ABLE MARINE ENERGY PARK

Representation on behalf of the Stone Creek Boat Club by Garry Lyon.

Figure 28-1 Cherry Cobb Sands site layout

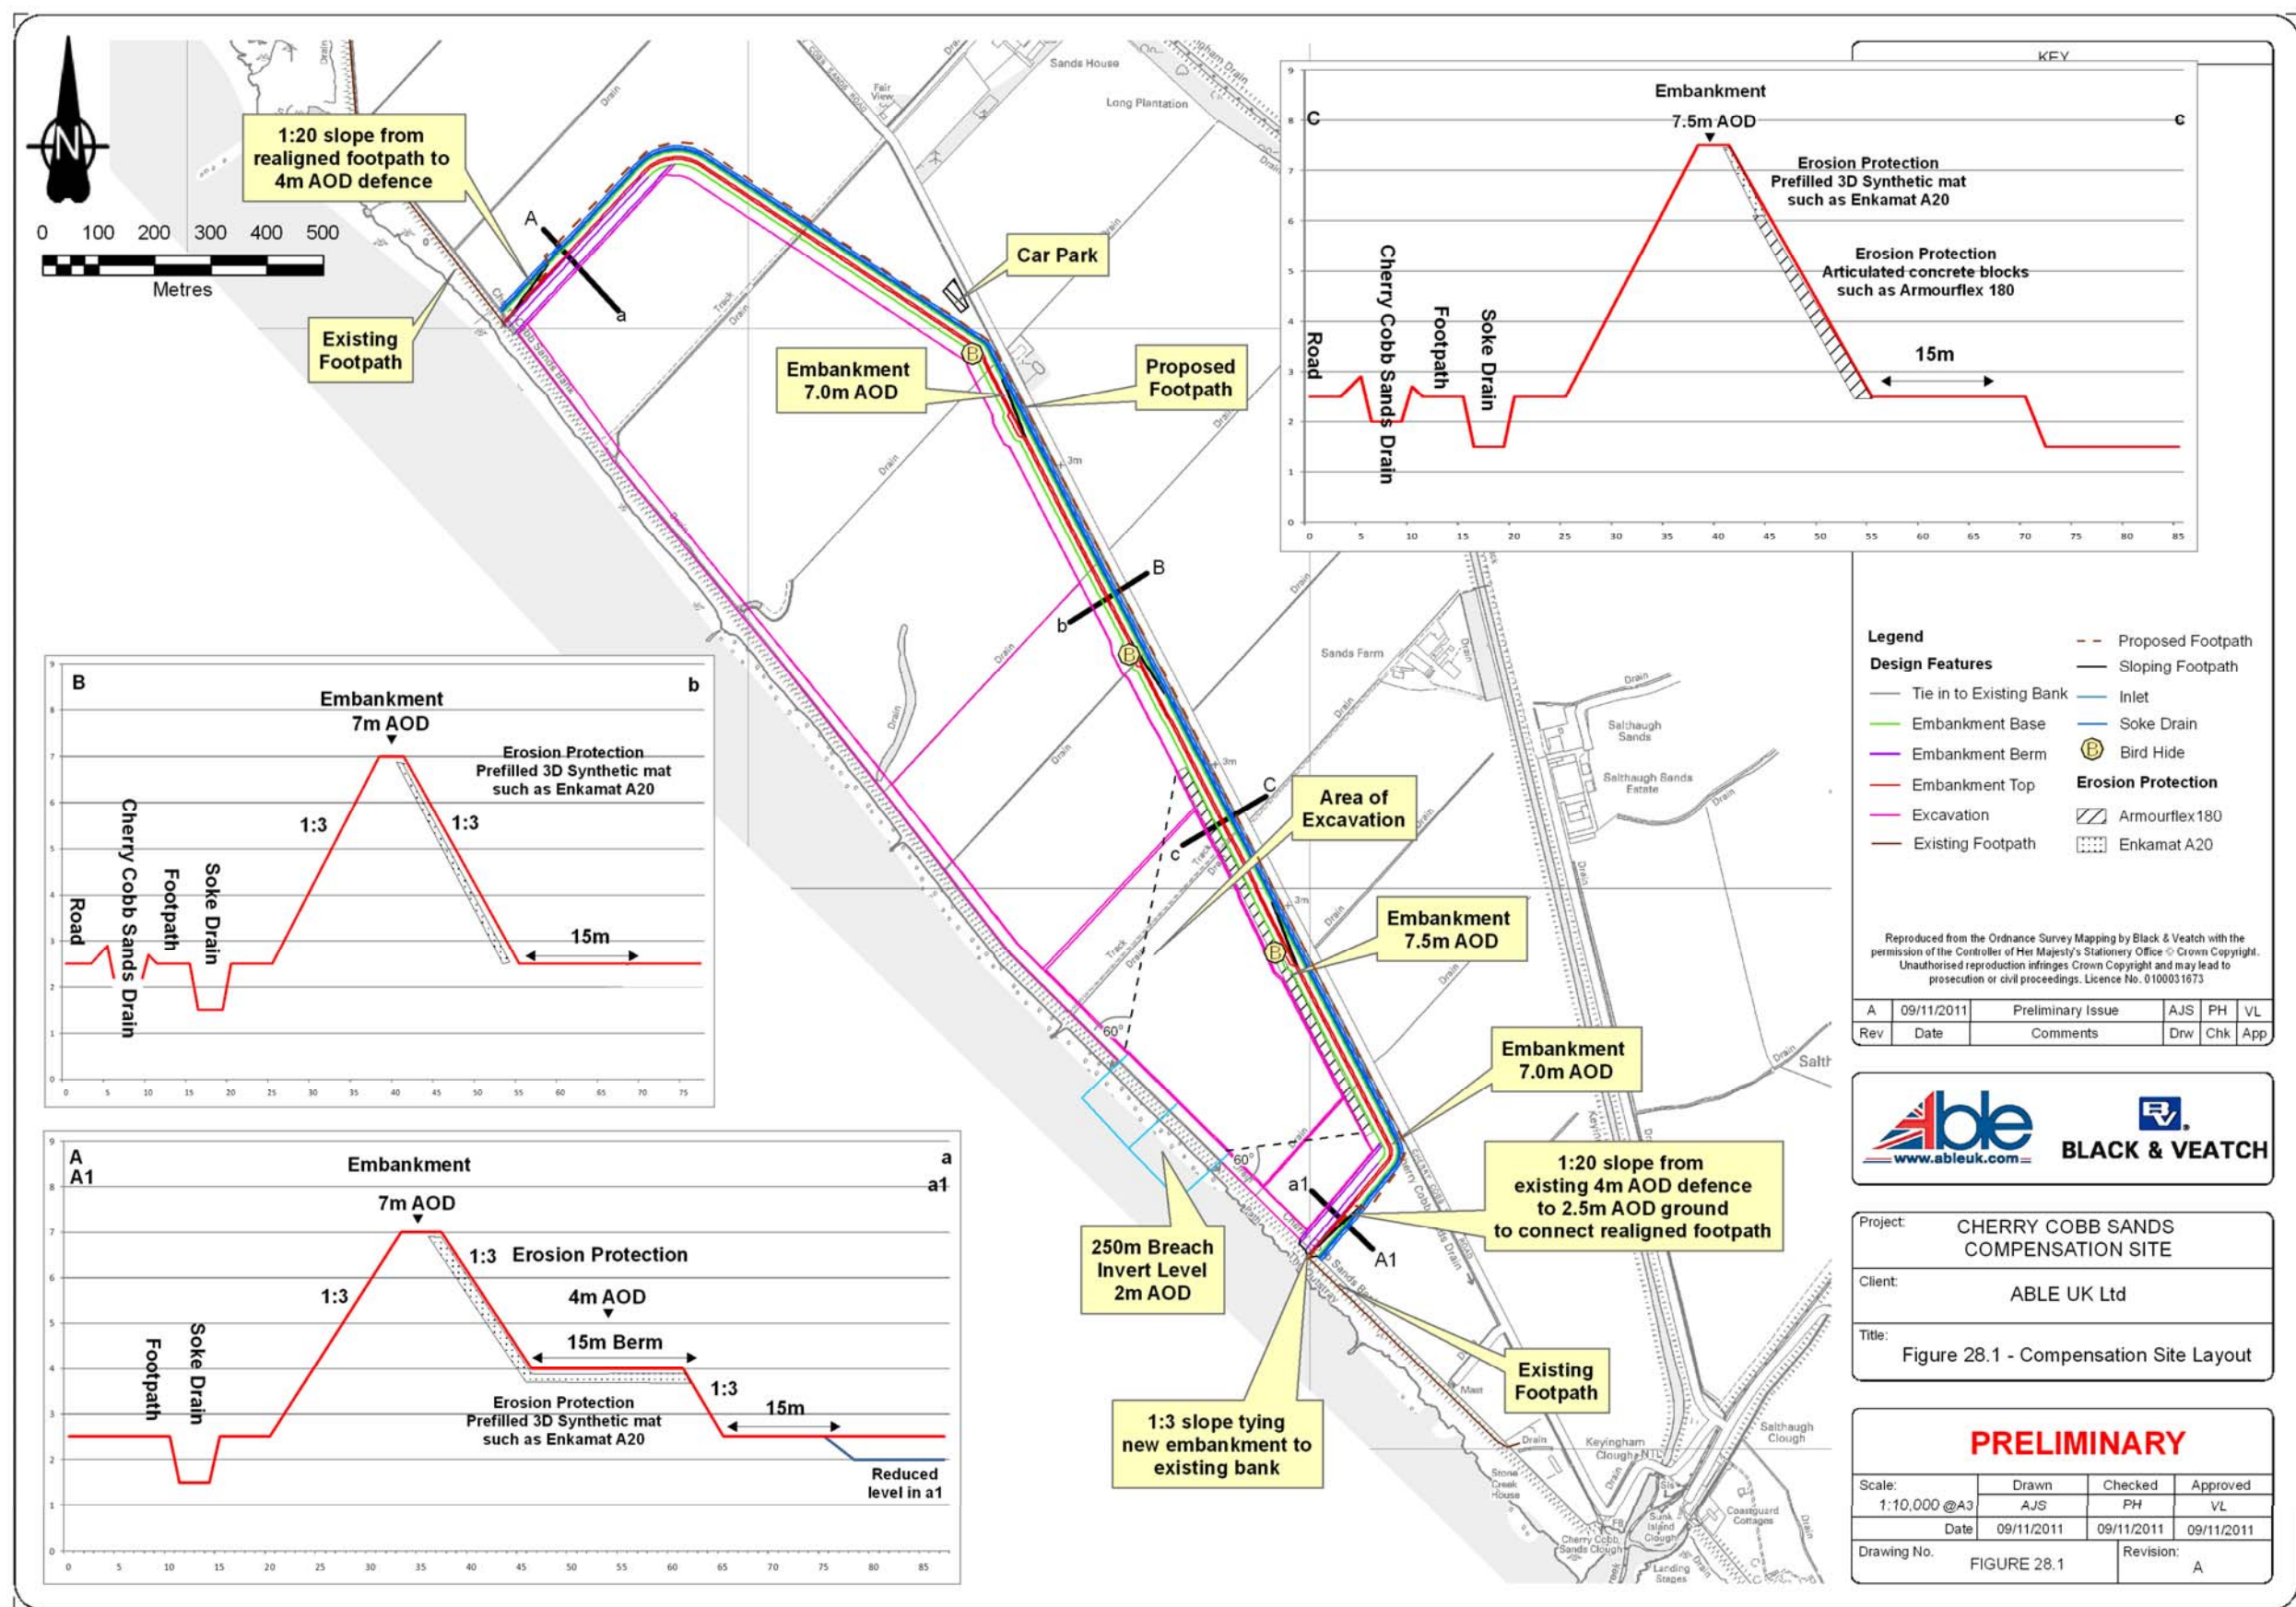
When the proposed compensation site is operational then priority of the water flows will change. Waters flowing down from the compensation site will form the main flow; a bar will form across the Stone Creek outfall. The height of the bar formed will depend upon the cycle of tides but 1 to 2 m high is not unreasonable.

A Bar forming across the Stone Creek outfall will reduce water flow time and volume.

Reduced flow time will reduce waters draining from the IDB sluice already critical at certain tide cycles and high rainfalls. This was graphically illustrated following the 2007 floods. ABLE mention this but understate the problem.

To remove the risk of any bar forming across the Stone Creek outfall the two water flows merging must be balanced out.

Instead of the current or envisaged situation where the two water flows merge at right angles to each other, the two flows must be encouraged to merge at an acute angle to each other.

Waters could be directed by introducing either a piled wall, baffle or stone cranch. The larger flow down stream from the compensation site would pass the formed channel creating a negative pressure in the Stone Creek outflow. This in turn would encourage greater water flows out of Stone Creek. This system has advantages for all.
